Local Land
Services
North West

12 April 2017

RE: North West Local Land Services' Comments on Santos Environmental Impact Statement (Narrabri Gas Project) – Application No. SSD 6456

Figure 10-2 Field Development Protocol inputs and context within field planning

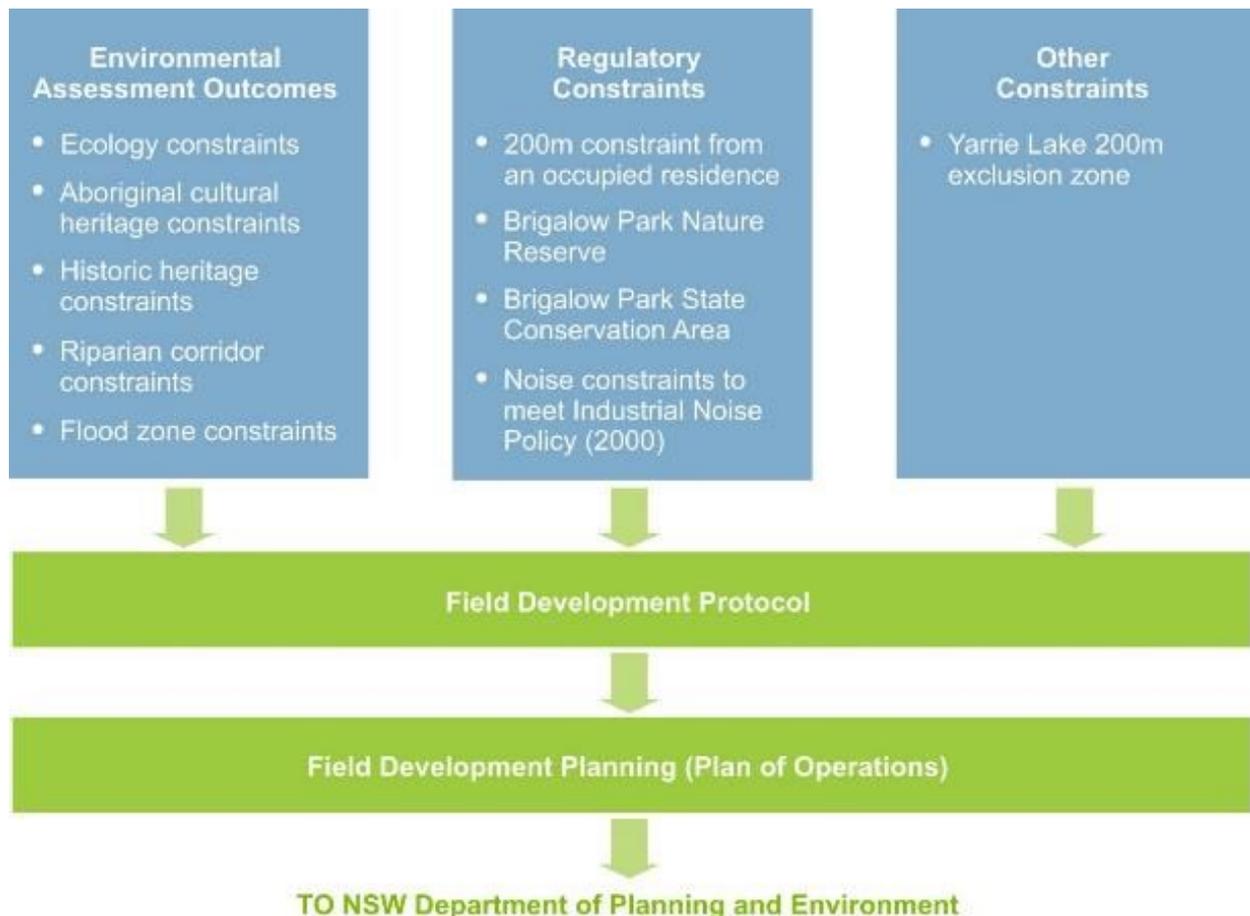
- The proposed Field Development Protocol identifies that disturbance to the high ecological sensitivity class is limited to 0.5% of total class area. NWLLS recommends that as only 4 or 5% of the high ecological sensitivity class exists, areas identified as high ecological sensitivity class be avoided (no go areas) for the location of gas well pads and associated infrastructure.
